CITY OF ALBUQUERQUE

November 24, 2008

RE: Alcalde Townhomes, (K-13/D049)
Engineers Certification for Release of Financial Guaranty
Engineers Stamp dated 10/02/2006
Engineers Certification dated 06/27/2008

**GRADING AND DRAINAGE PLAN**

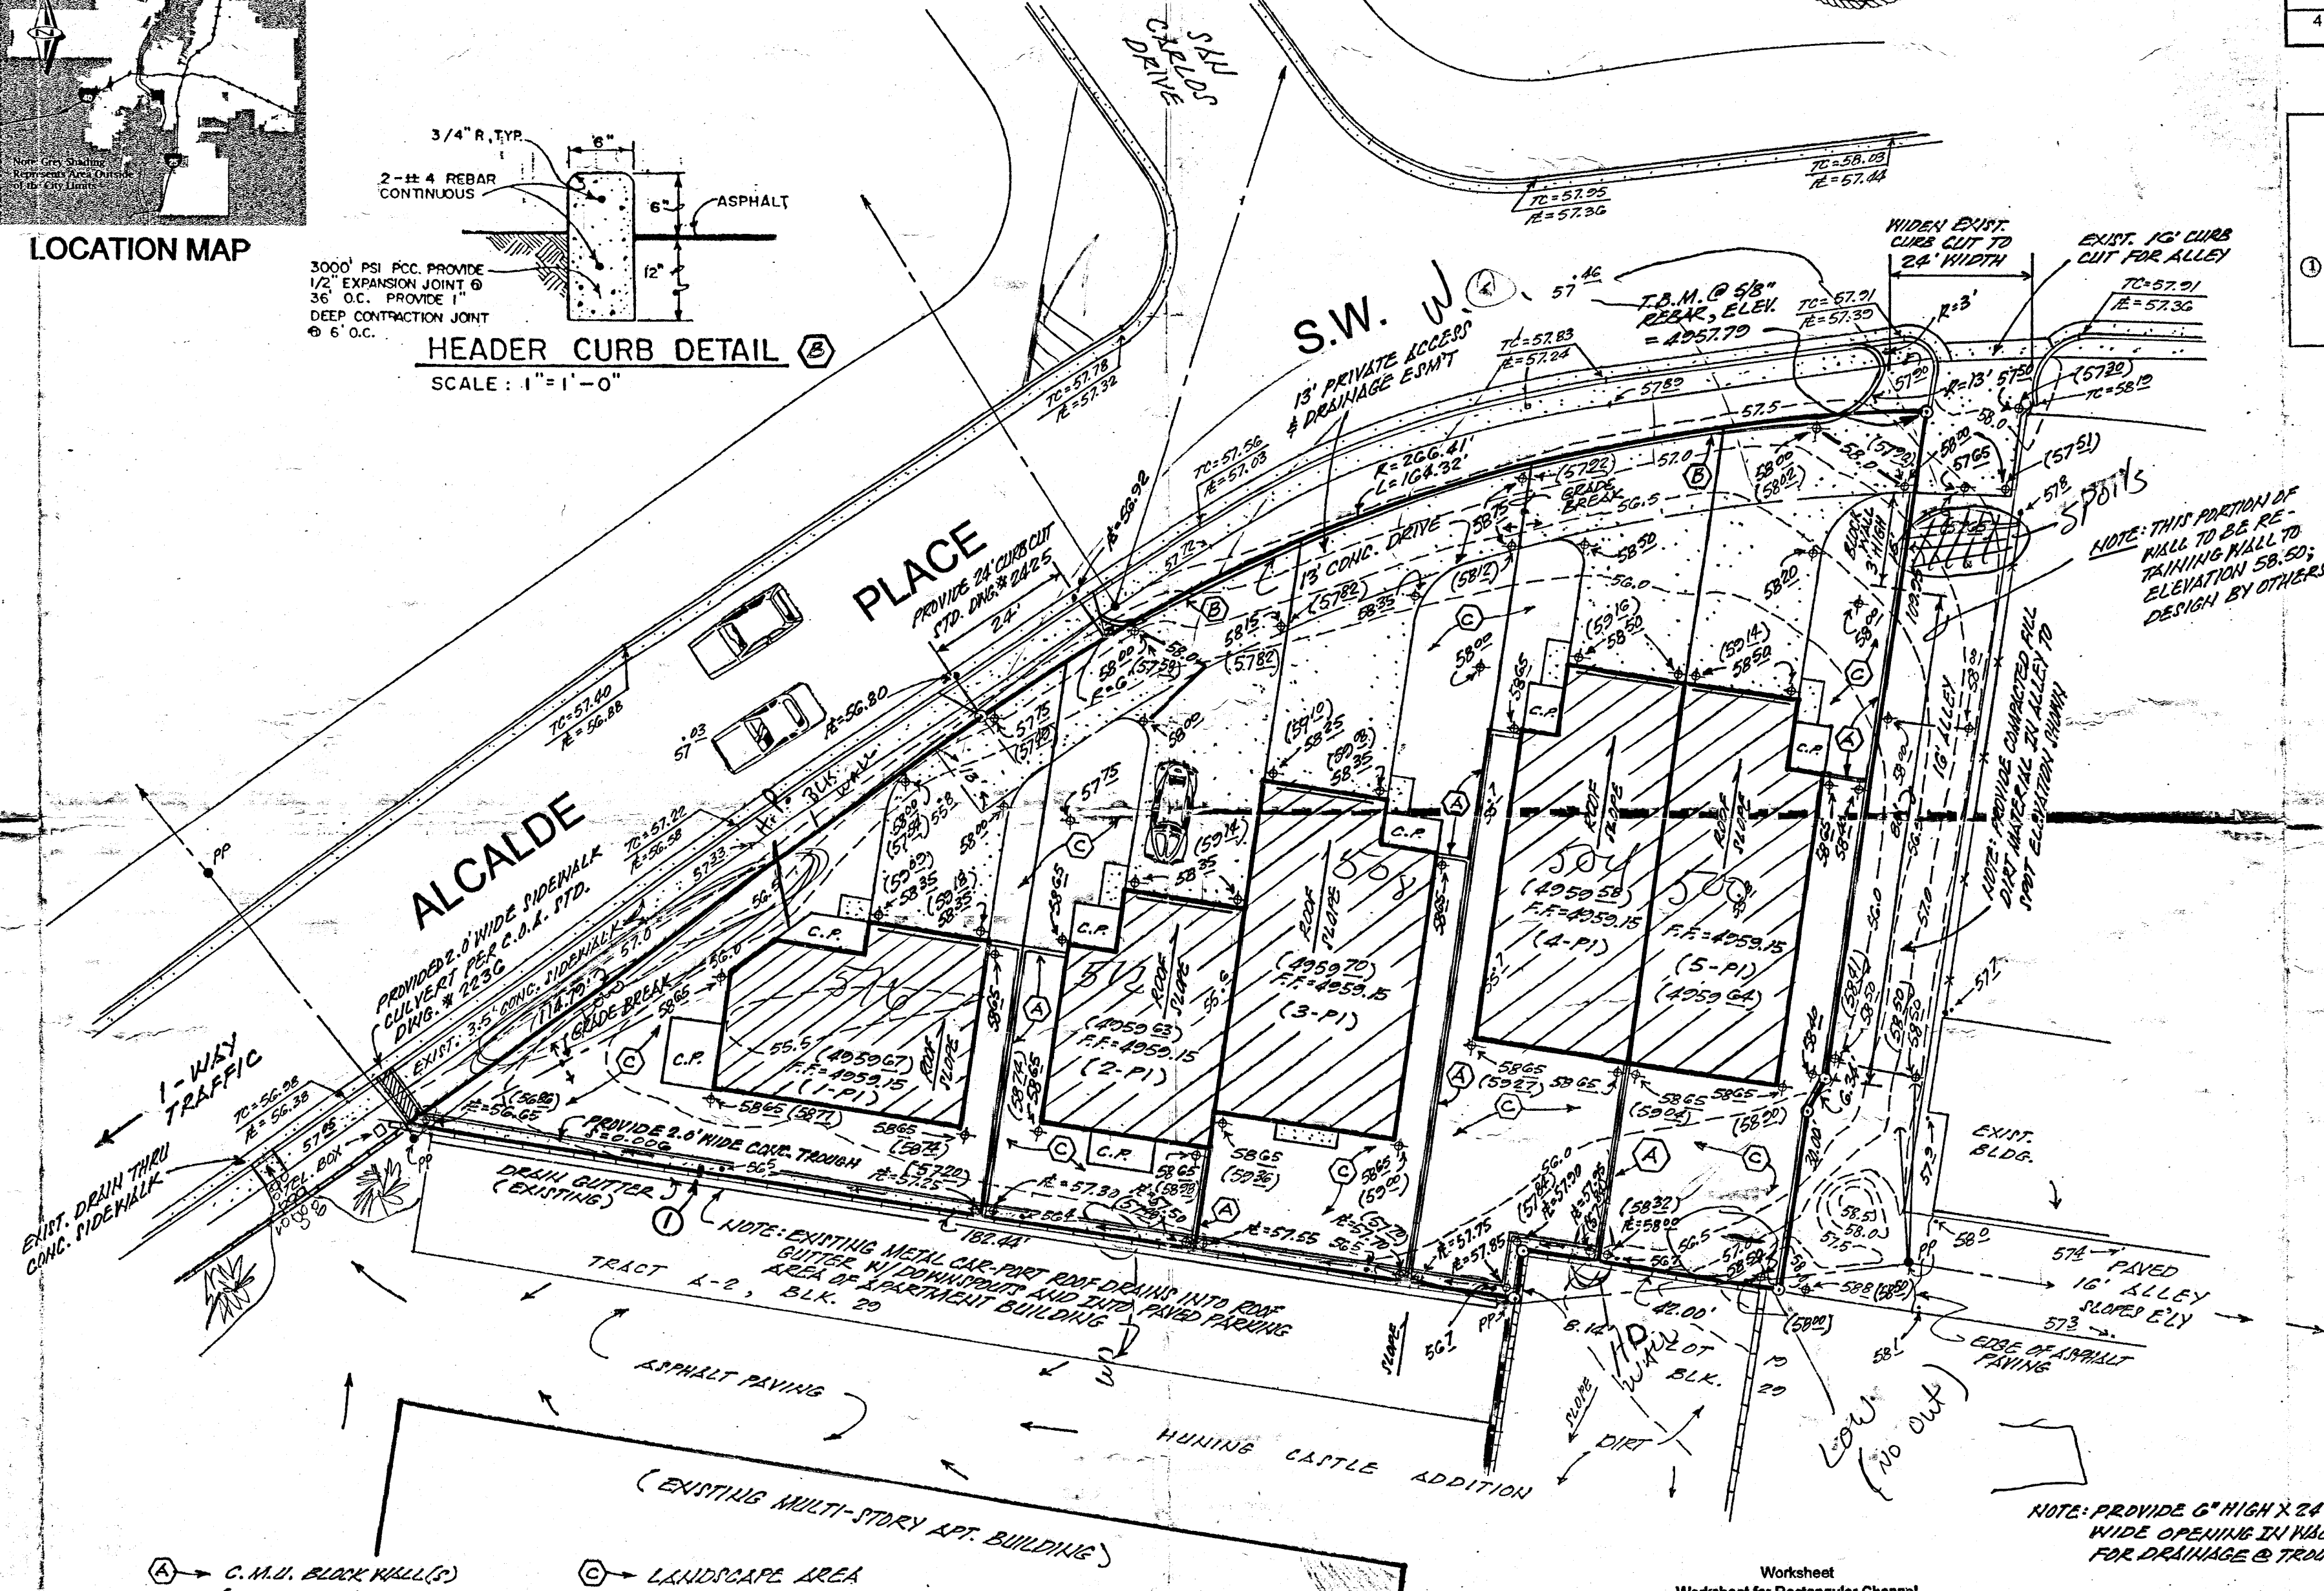
- The apartments to the south are introducing some runoff onto this site. A channel must be provided to drain that water and the individual rear yards west to Alcalde without internal ponding. A new sidewalk culvert will be necessary.
- The existing CMU wall is not designed for soil retention. With the amount of fill you will be importing, retention structures will be necessary. Please provide a wall cross-section and the appropriate top and bottom of wall elevations as necessary.
- Please quantify the amount of offsite flow entering the site both from the apartments to the south and from the adjacent alley under both the existing and developed conditions.
- How will the alley drain? Will it discharge north to Alcalde / Lead or drain west through the new development?
